Arun District Council
Arun Civic Centre
Maltravers Road
Littlehampton
West Sussex BN17 5LF
Planning & Building Control General Enquiries
Tel: (01903) 737756 Fax: (01903) 730442
Dx: 57406 Littlehampton
Minicom: 01903 732765
e-mail: planning@arun.gov.uk
website: www.arun.gov.uk/planning

Application No: P/159/21/PL
Site Address: 253-255 Inglenook Hotel Pagham Road Pagham PO21 3QB
Description of works: Variation and removal of conditions imposed under P/58/19/PL for the variation of condition 2-plans condition & 16-external lighting of roads & footpaths & removal of conditions 11-footpath access through Hotel site & 13-signage of vehicular access previously proposed.

Thank you for your internet representation made on 20th December 2021 which has been recorded as an objection with the comments as follows:

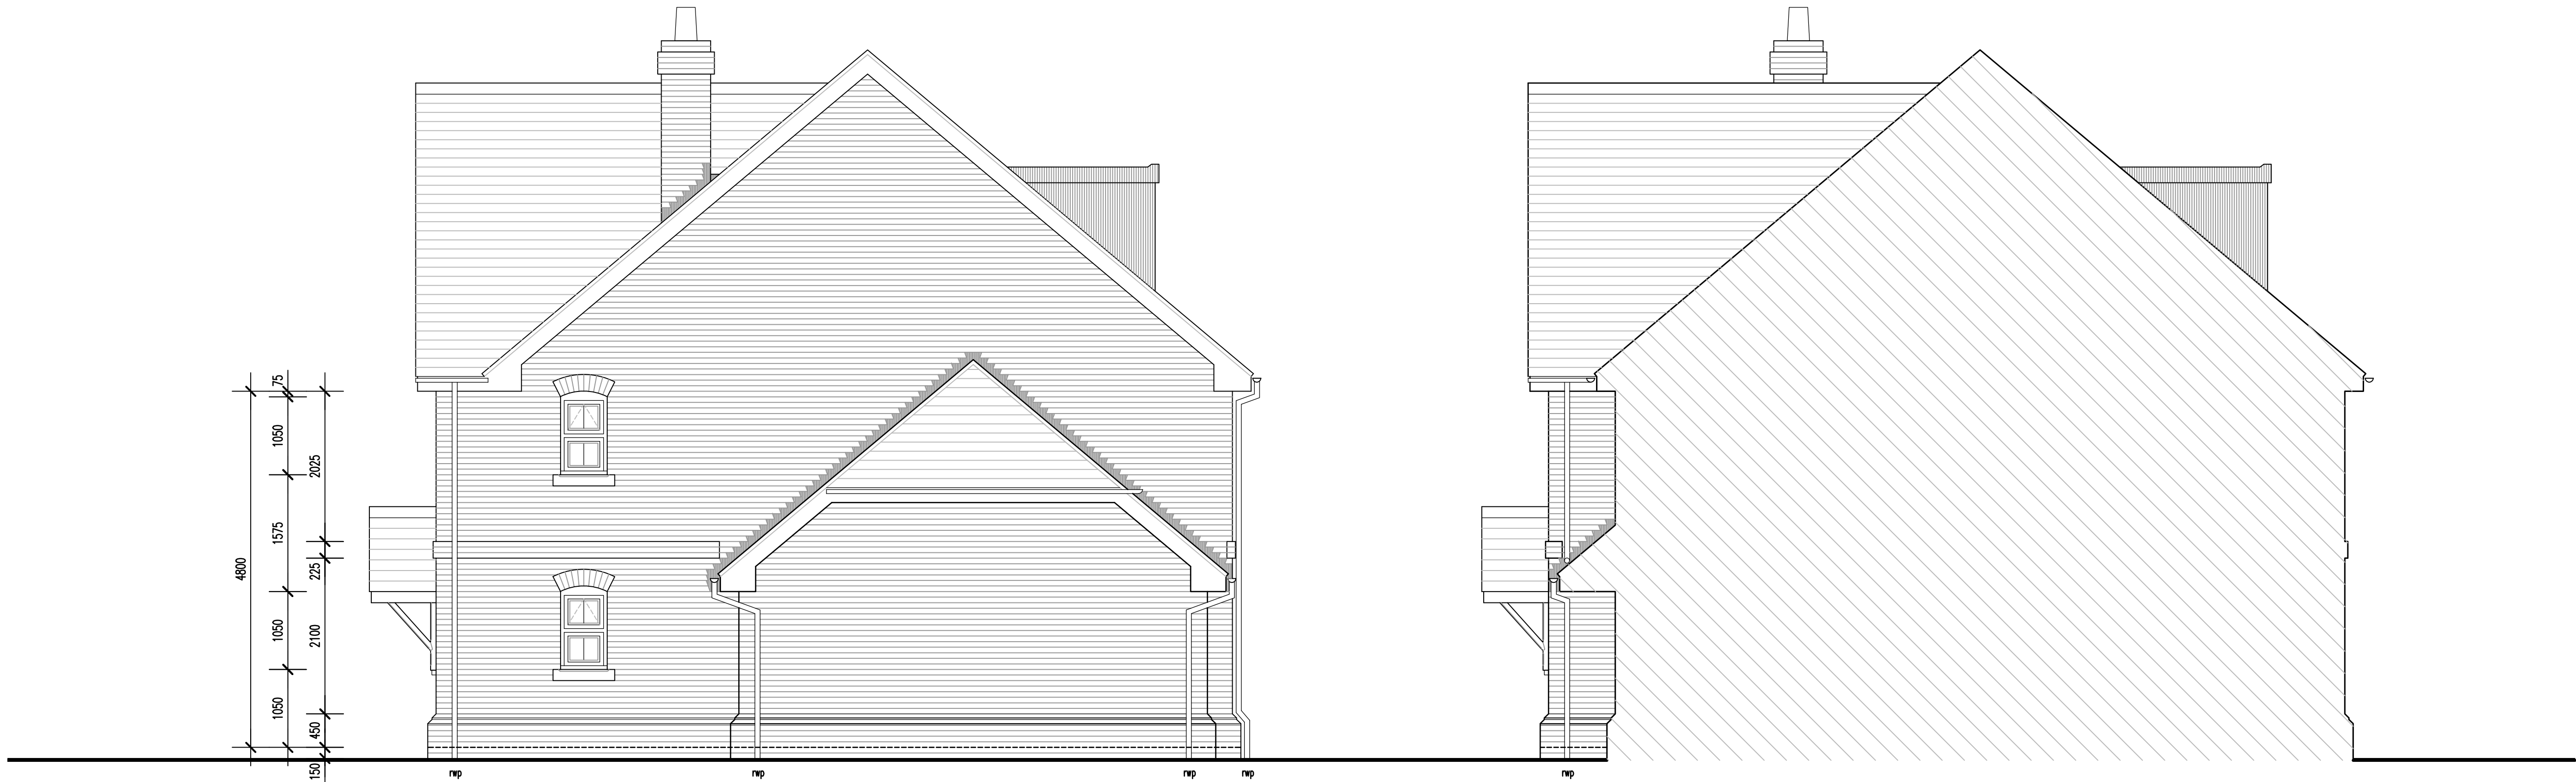
Loss of light was already a disadvantage for residents along Mill Farm Drive and the insertion of dormers and rooflights in the four dwellings will now be very invasive. The addition of the 2nd floor does not reflect the character of the site or surrounding area, in particular the properties of Mill Farm Estate. Windows will be looking down onto single storey bungalows and conservatories. They will suffer loss of light and privacy with an unacceptable level of overlooking contrary to ADC Local Plan policies D DM1 3 (Impact).

Access Overview and Visibility Splays

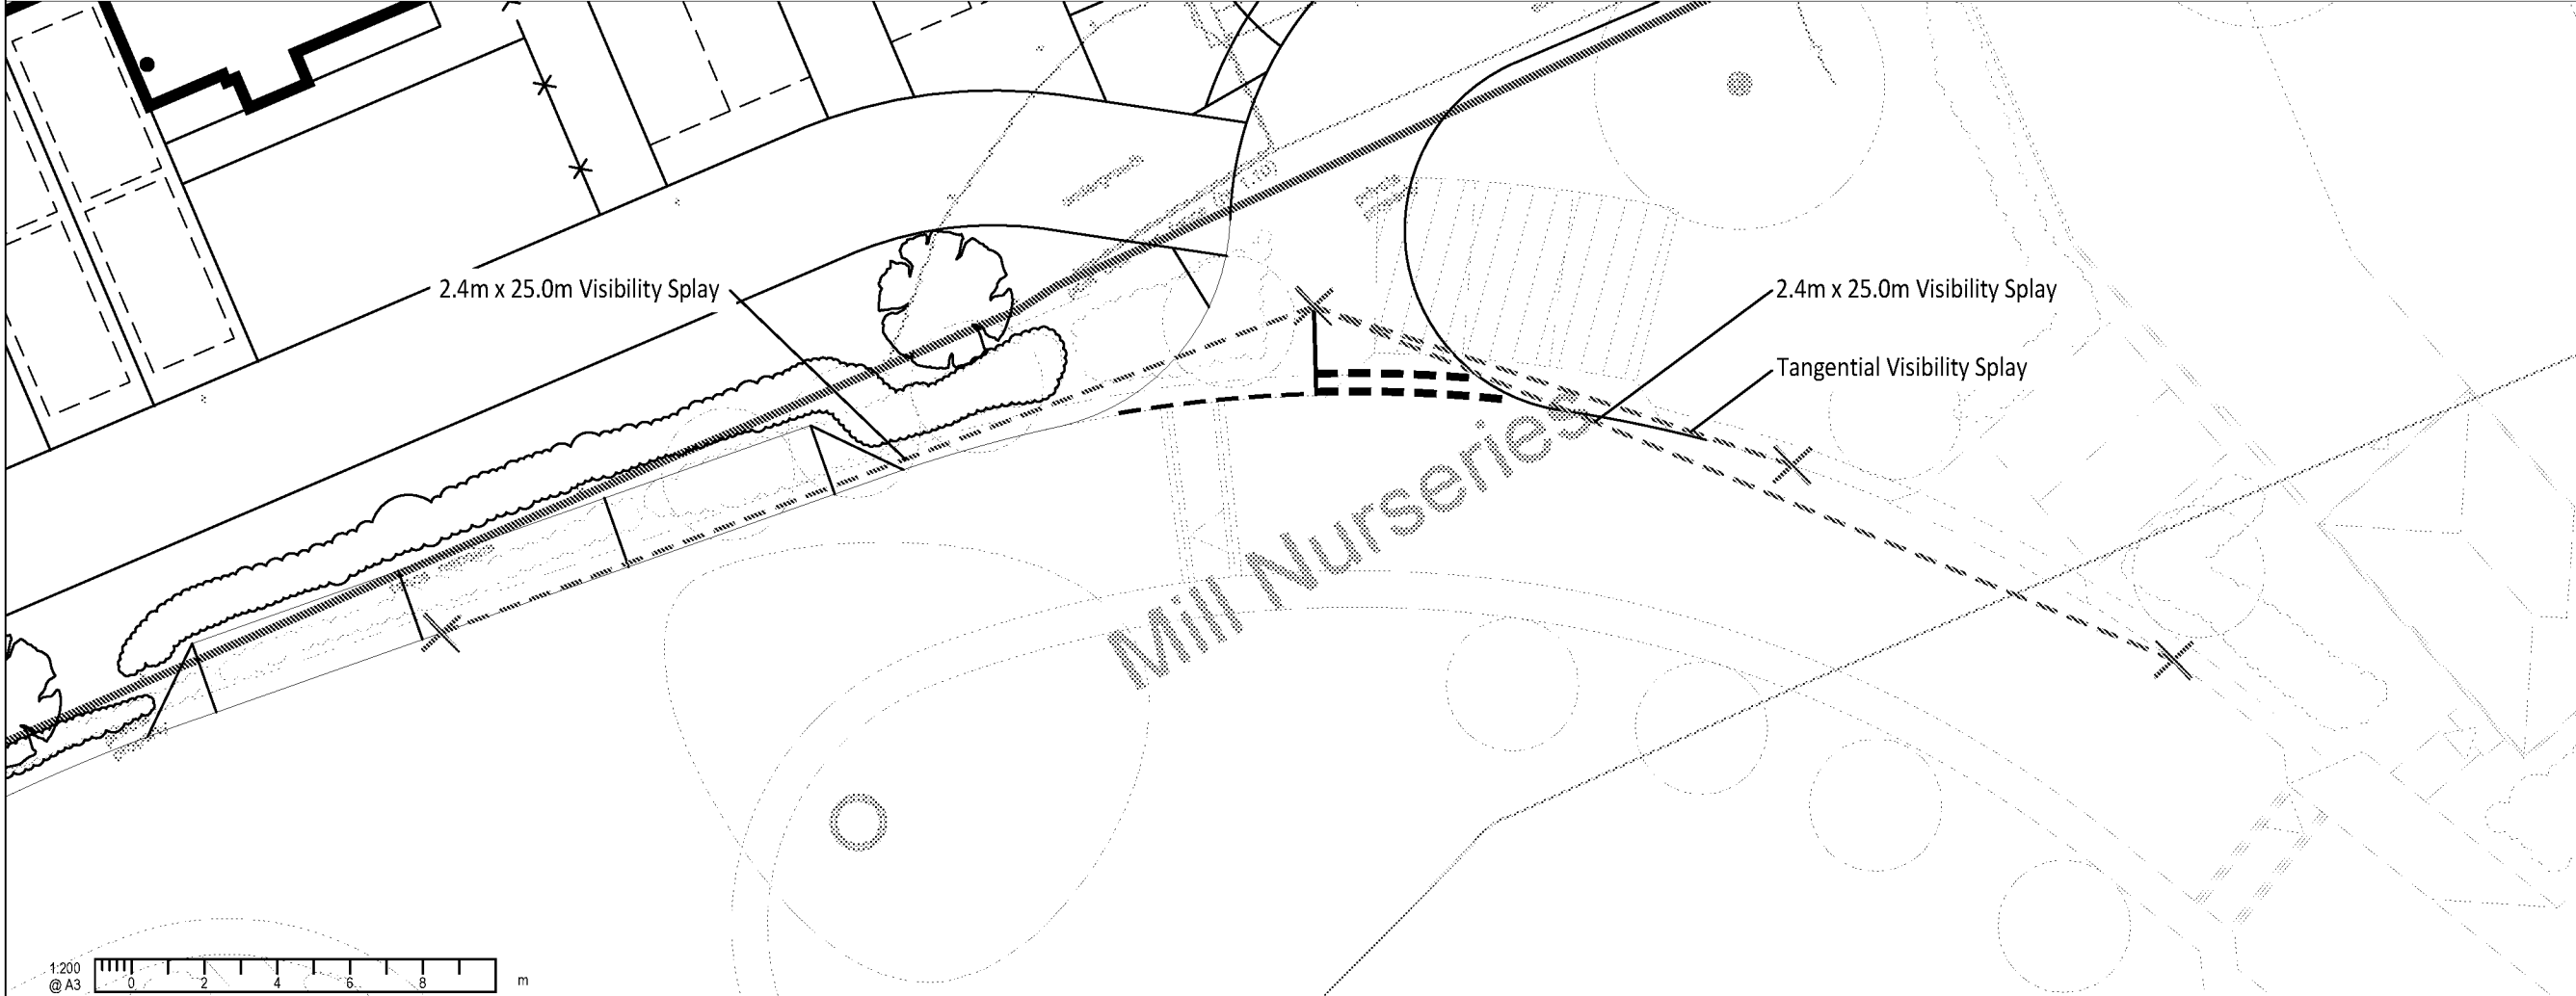
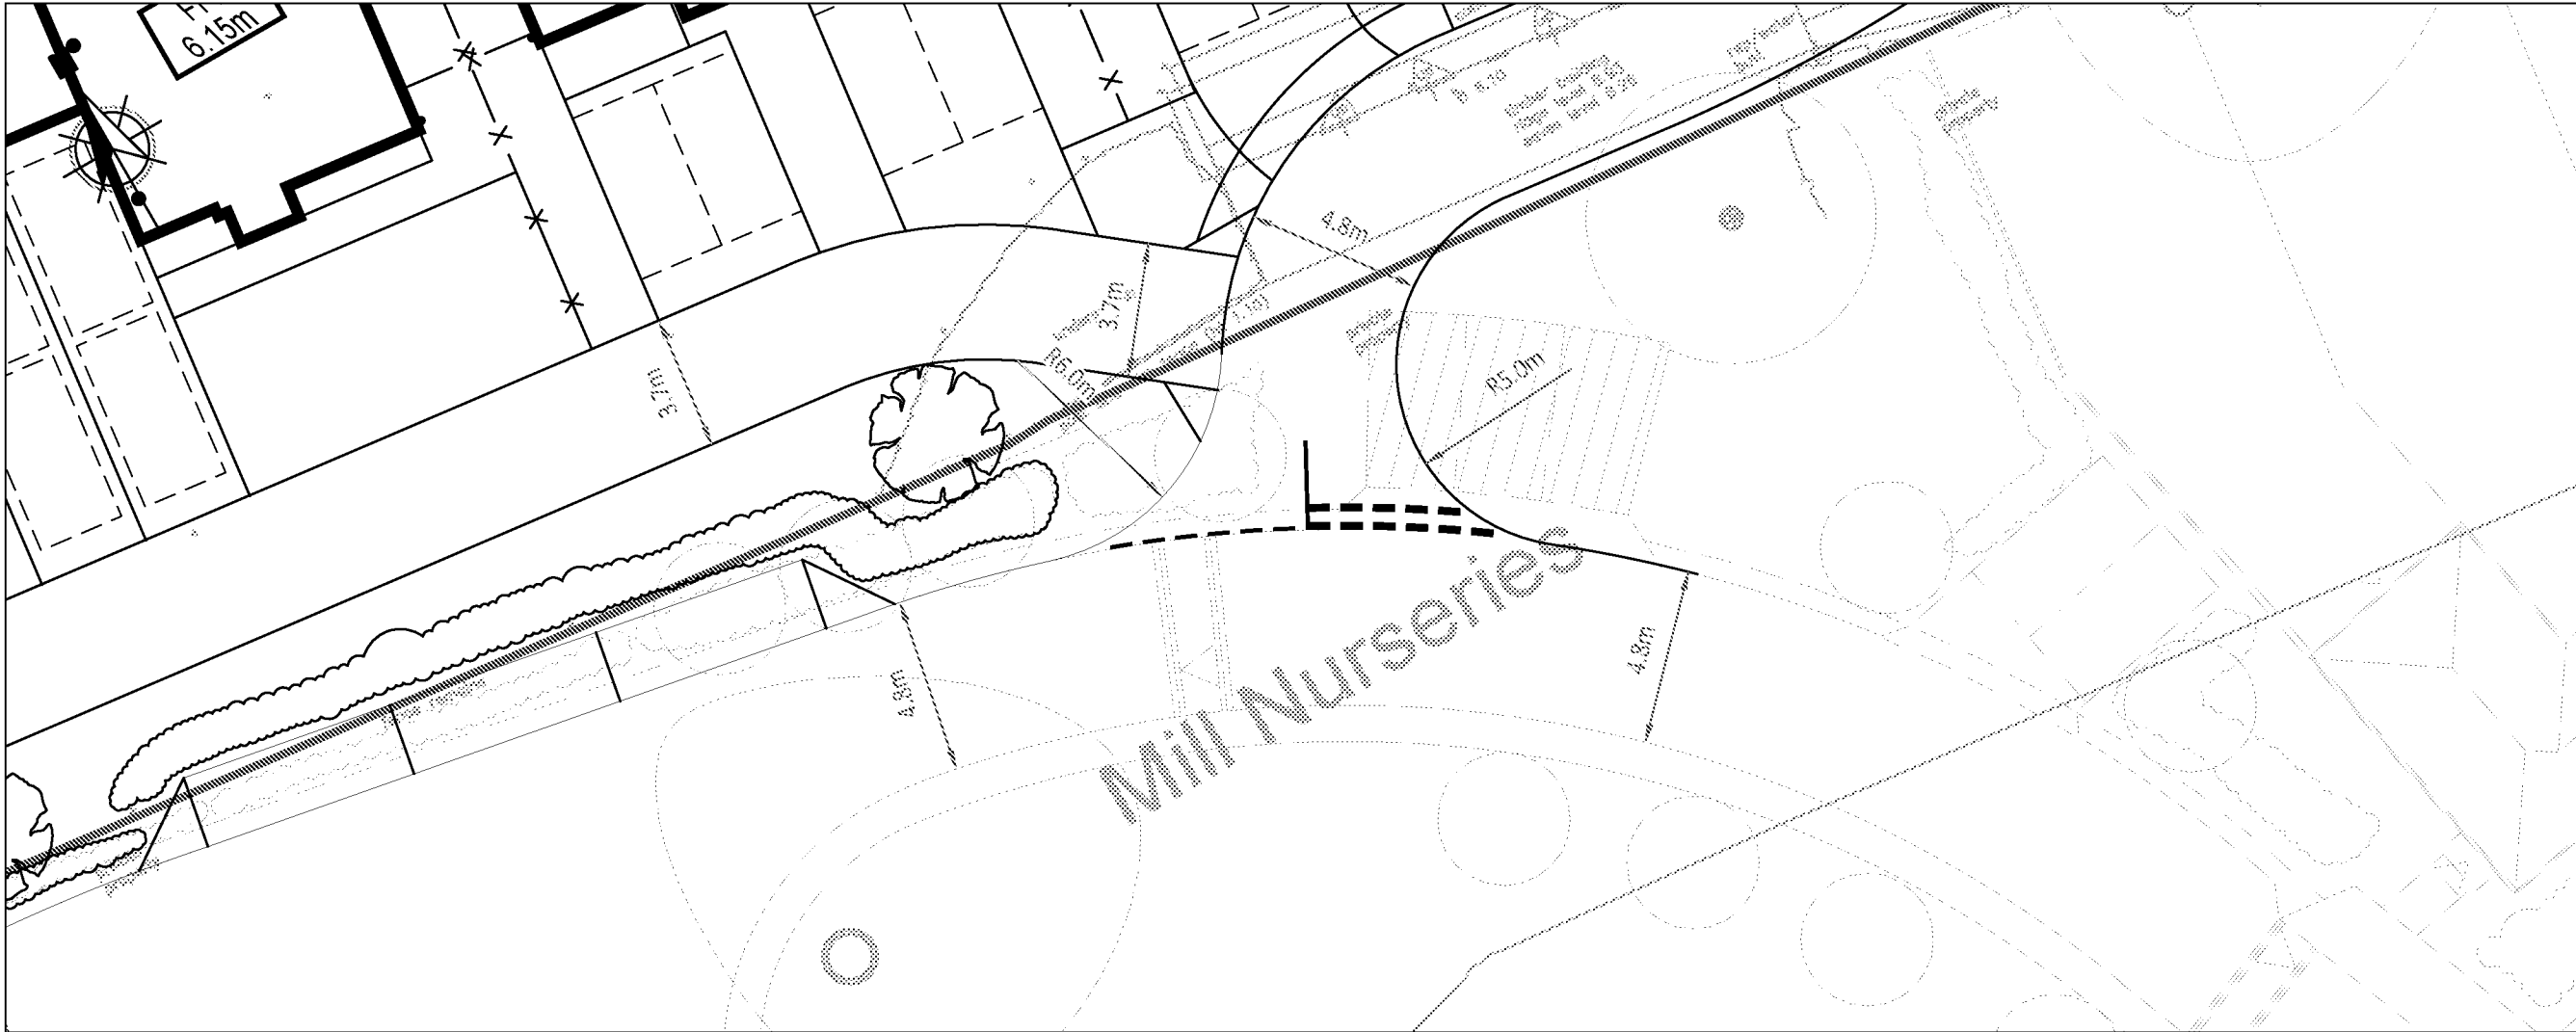
This new application proves that ADC were right to refuse, even though their decision to refuse was against the Highways recommendations, perhaps ADC should have put forward a stronger case. Highways had no jurisdiction over the proposed access into the Pagham Road just as they don't have jurisdiction over Spinnaker View access, which is an unadopted and Private road exiting into the Pagham Road.

Obviously, the potential cost of crossing the ransom strip to provide an alternative access through Spinnaker View will reduce the profit from this development.
